**Consultation Response from KC,
Ecology Unit**

2023/93749 77 , Latham Lane, Gomersal, Cleckheaton, BD19 4AP

Erection of detached dwelling with integral garage (amended house type)

Date Responded: 08/02/2024

Drawing no
22-1185/(AL)200

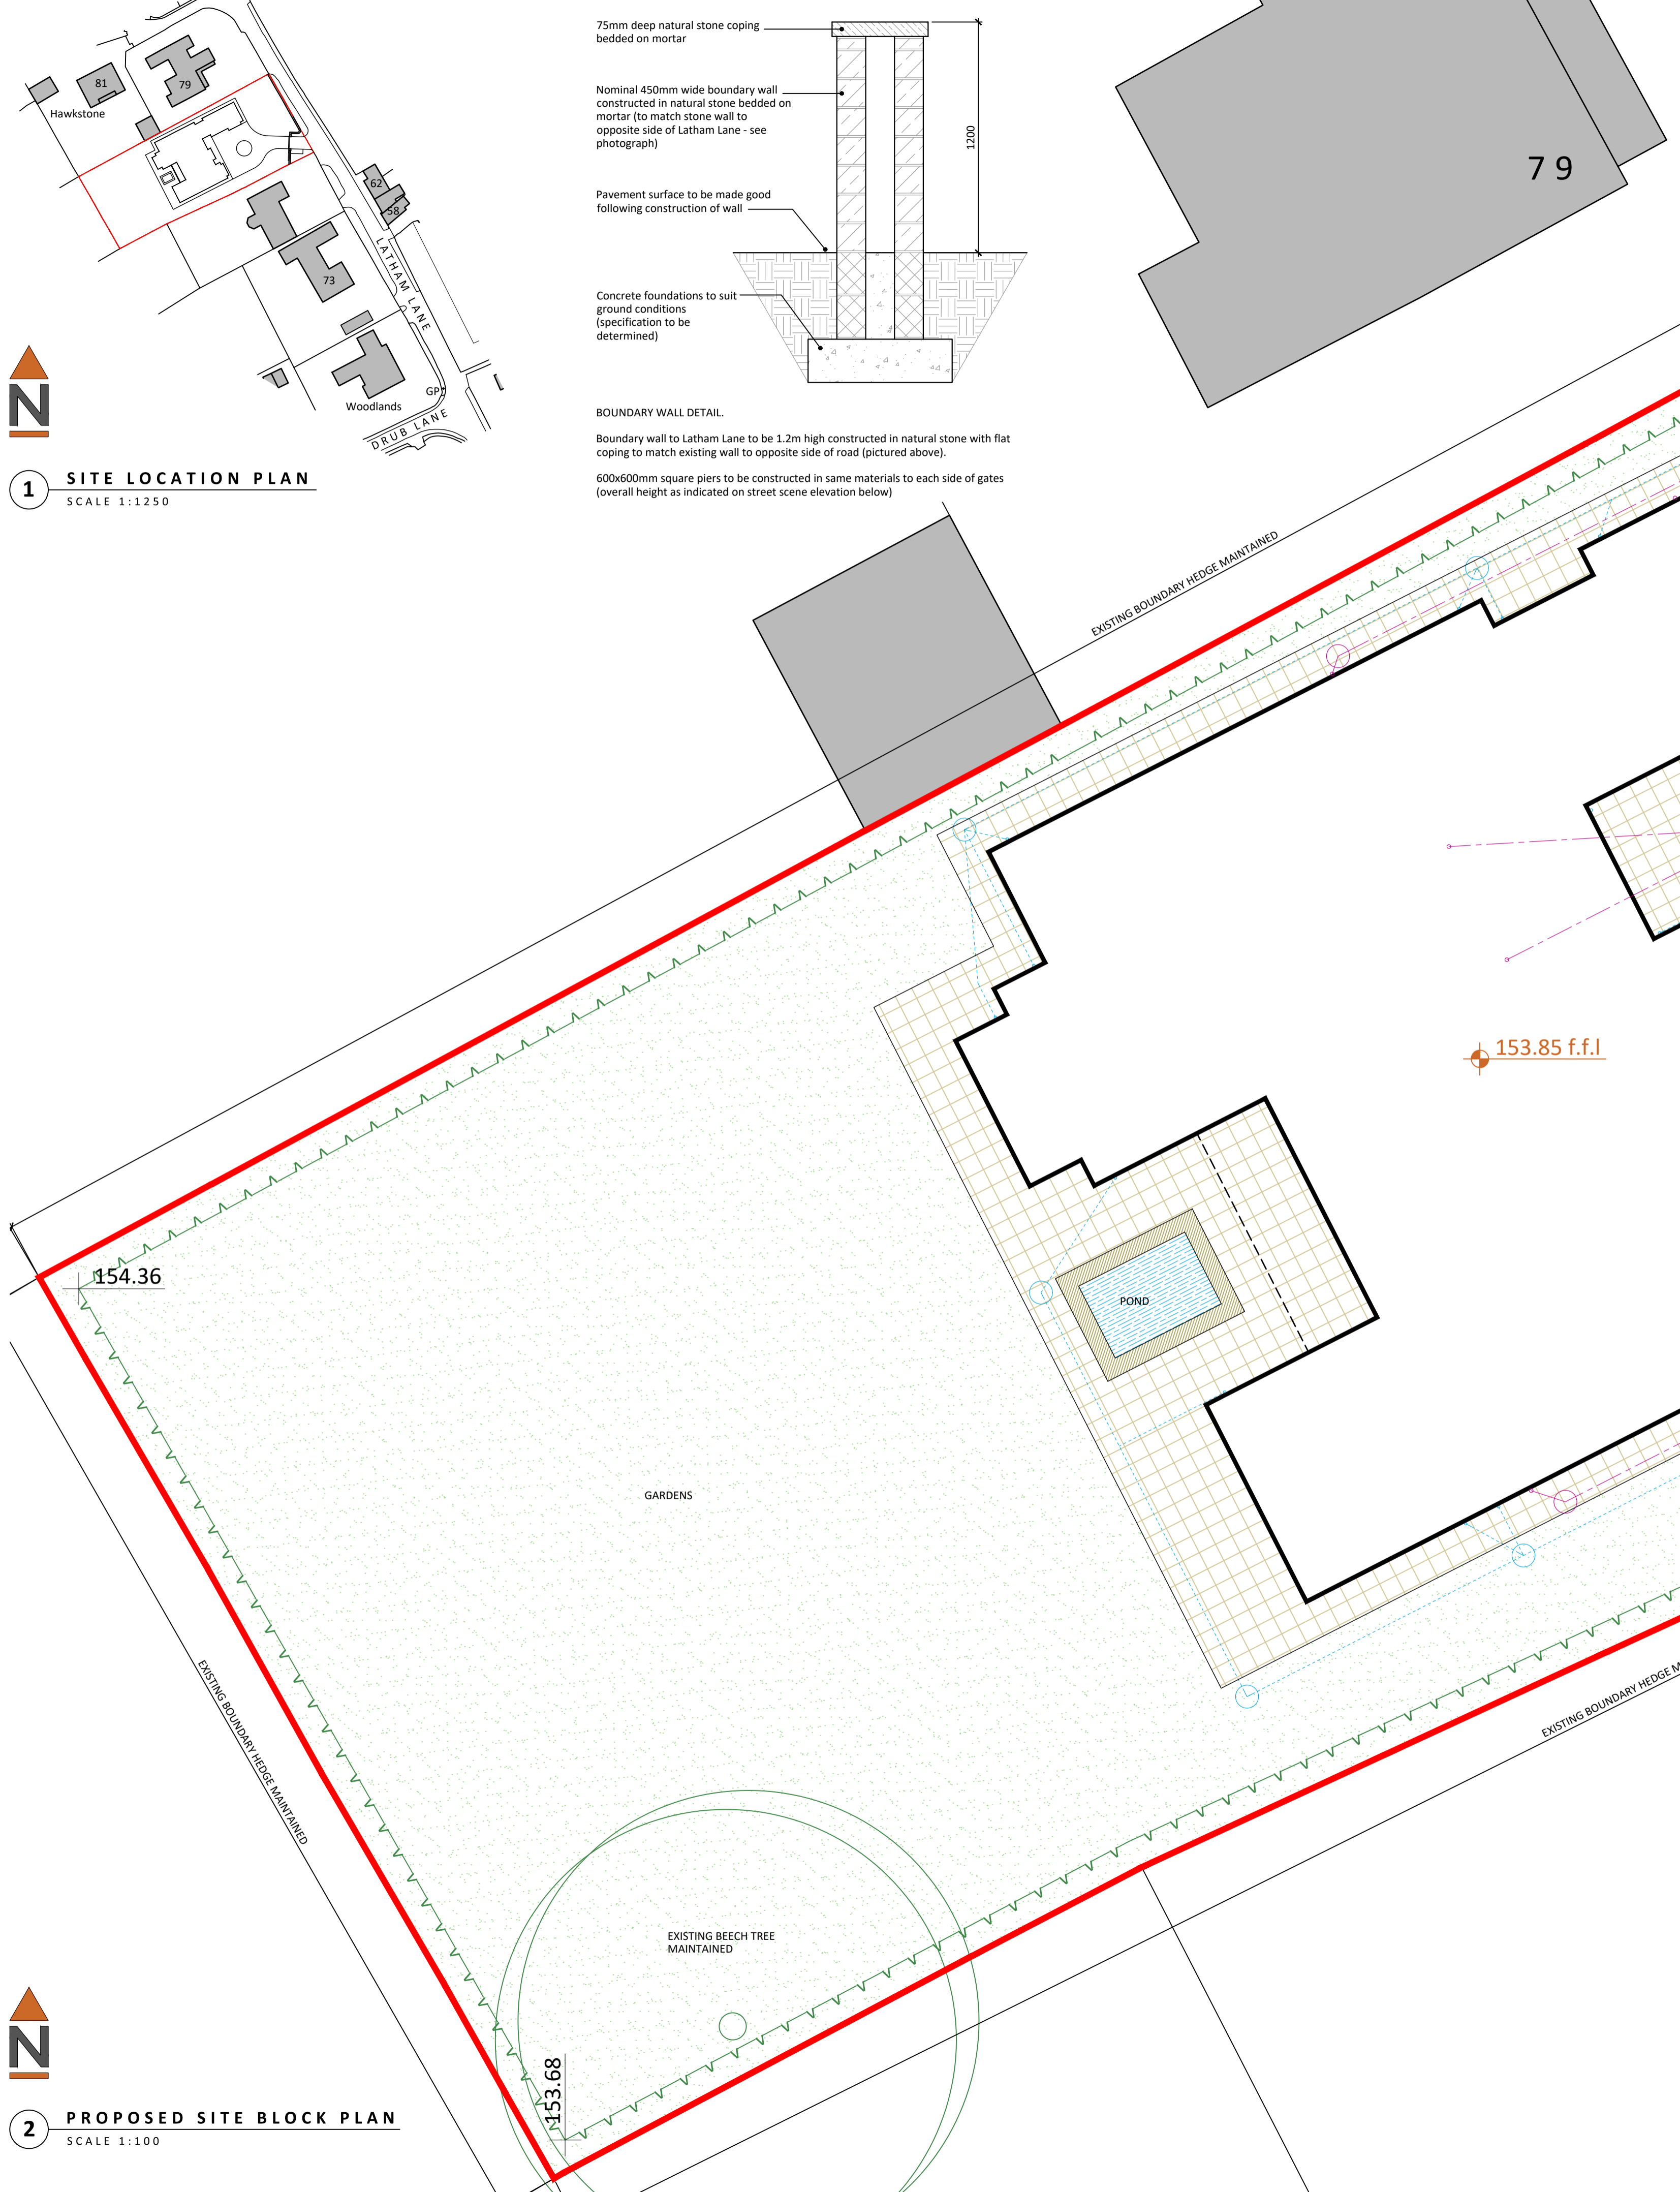
Prior to the most recent previous permission at the site, the updated application has incorporated a number of the proposed conditions into the submitted plans, including the placement of integral bat and sparrow boxes, along with planting of native species at the site. As such, the submitted plans should be strictly adhered to throughout the development.

As such, I have no objection to these proposals, and they will allow for an uplift in faunal provisions at the site. However, in order to ensure there are minimal impacts to ecological receptors, the following condition is recommended.

1. No site clearance works shall take place between 1st March and 31st August inclusive, unless a competent ecologist has undertaken a careful, detailed check of the site for active birds' nests immediately before the site is cleared and provided written confirmation that no birds will be harmed and/or that there are appropriate measures in place to protect nesting bird interest on site. Any such written confirmation should be submitted to the local planning authority.
